From: Martyn White
Sent: 22 March 2019 11:56
To: Planning.Responses
Cc: Anita Gardner
Subject: AB/17/19/DOC

AB/17/19/DOC

The current application relates to the approval of details reserved by condition imposed under reference AB/99/18/L. Details related to the following conditions have been submitted:

Dwg No GFD1 Revn.

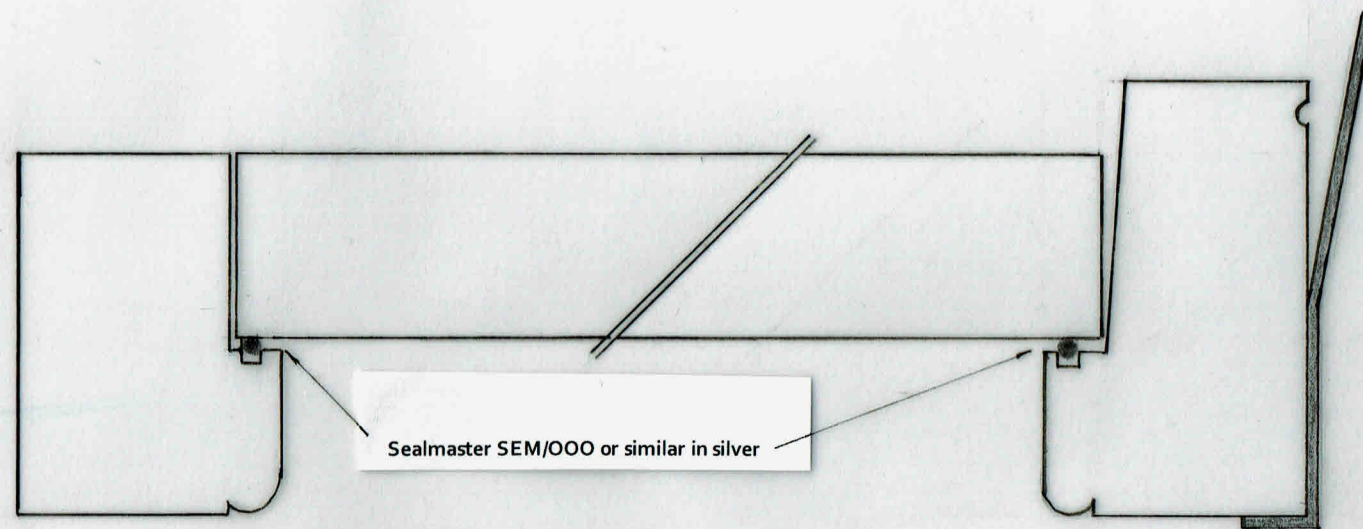
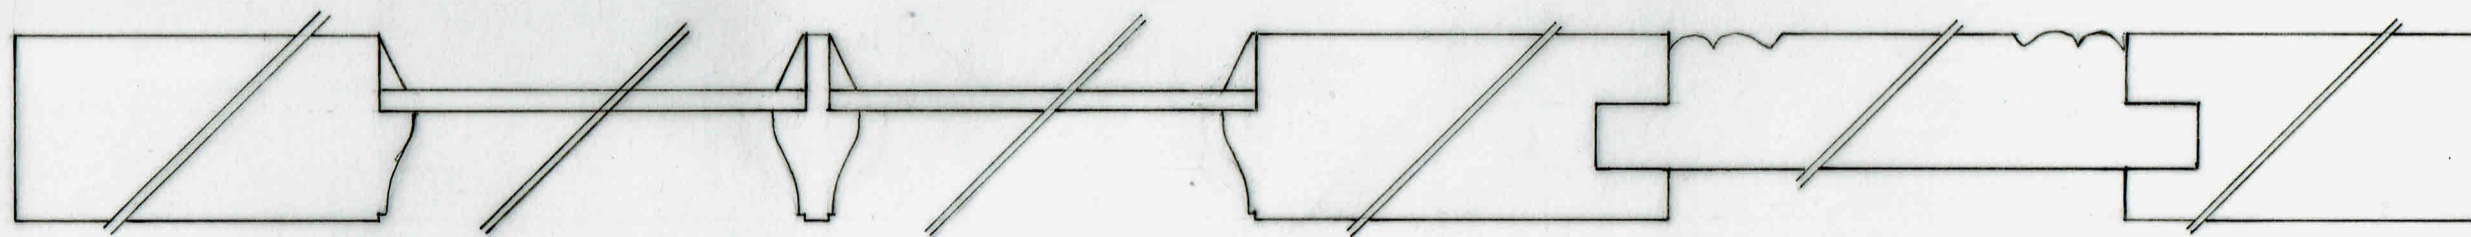
The information supplied indicates that some of the existing windows will be repaired, rather than replaced in their entirety as previously suggested. Such an approach is supported.

Reference is made that the measurements provided as part of this application have been taken from the existing windows. This will enable the windows to look exactly the same as they do now. Such an approach is supported. This condition can be discharged.

Drawing No: FR1.1

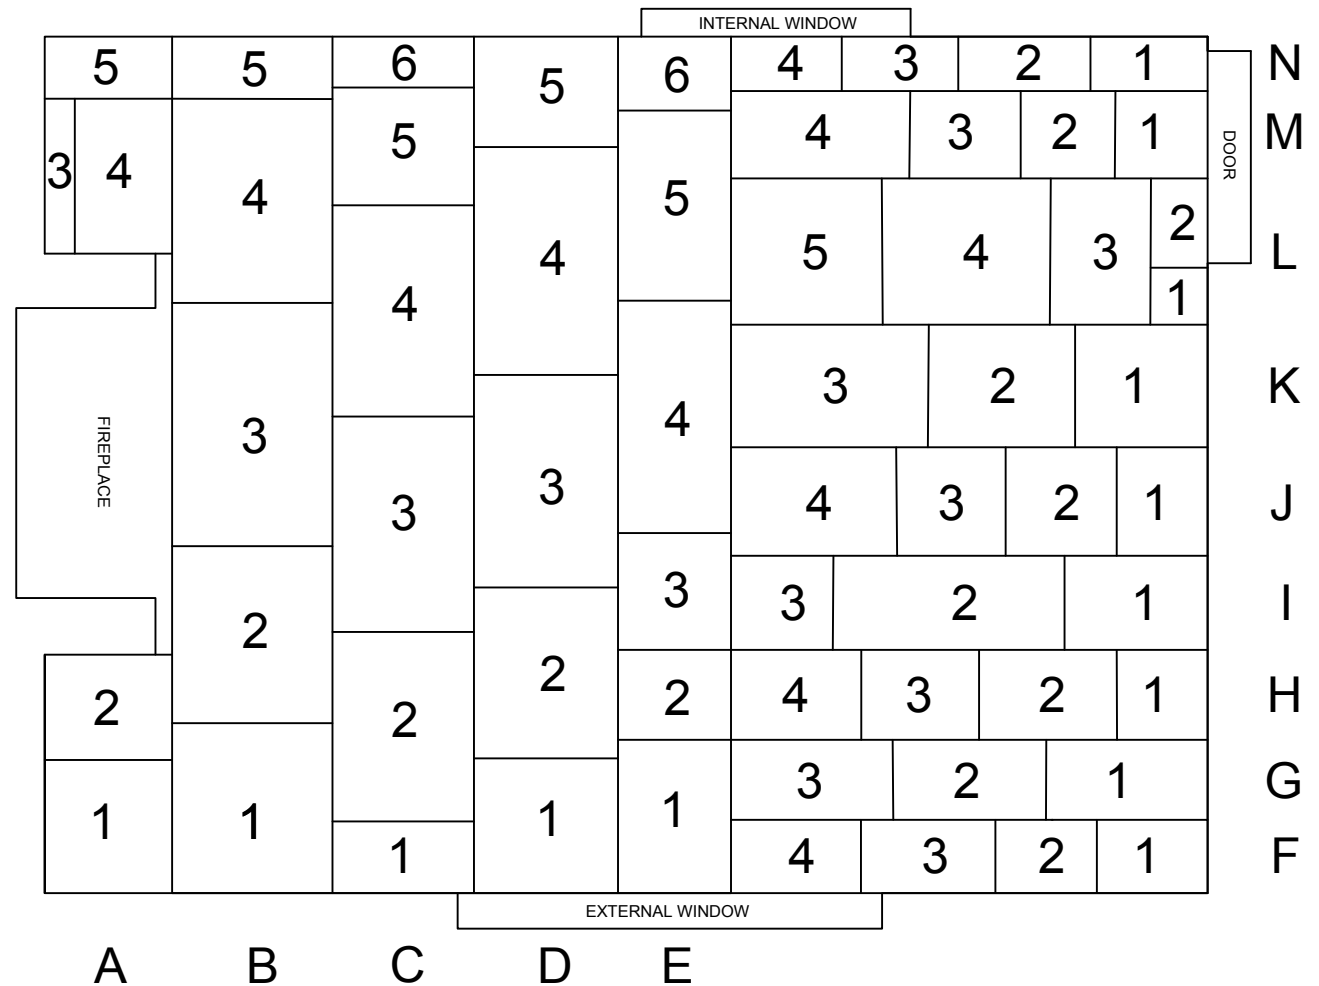
Detailed drawings have been provided for both the front basement room and the hallway. It is assumed that these have been provided to us following a survey? Pictures of the existing floor should also be provided for information.

The method statement for the York Stone flooring only goes as far as recording, removal and storage. Further information should be provided relating to the re-laying of the slabs.

FIREPLACE SURROUND SCALE 1:20

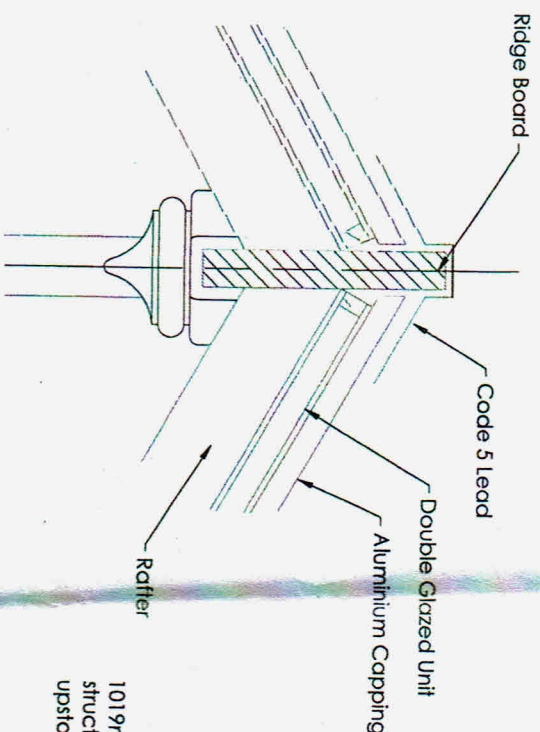
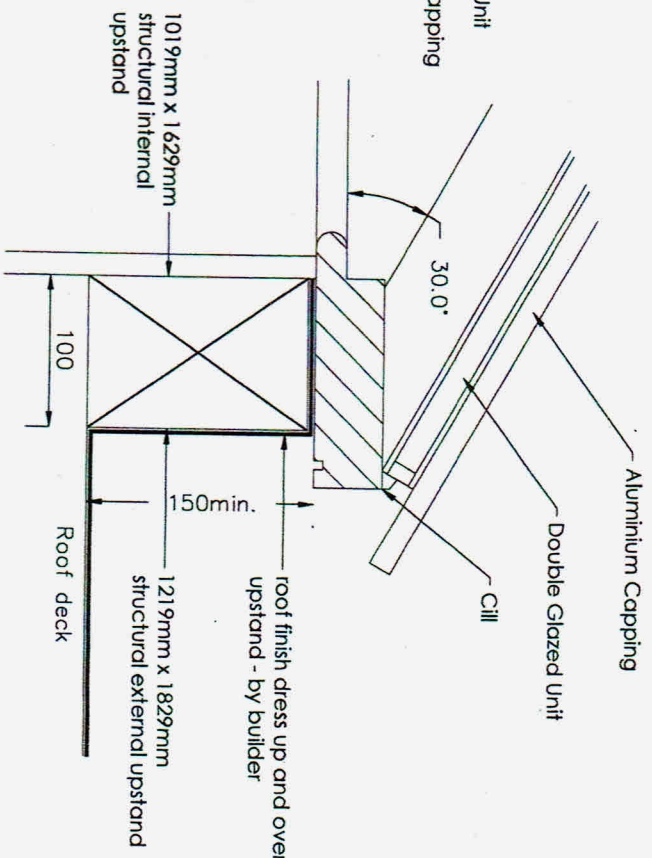
Rooms G2 and 3: The retention of the fireplace surround in room G2 is acceptable, as is the concept of replicating the fireplace in room G3. I note that a very small architectural drawing is included in the statement; you may wish to see this as an actual drawing so that the details can be confirmed. The drawing does not appear to be part of the application in front of me.
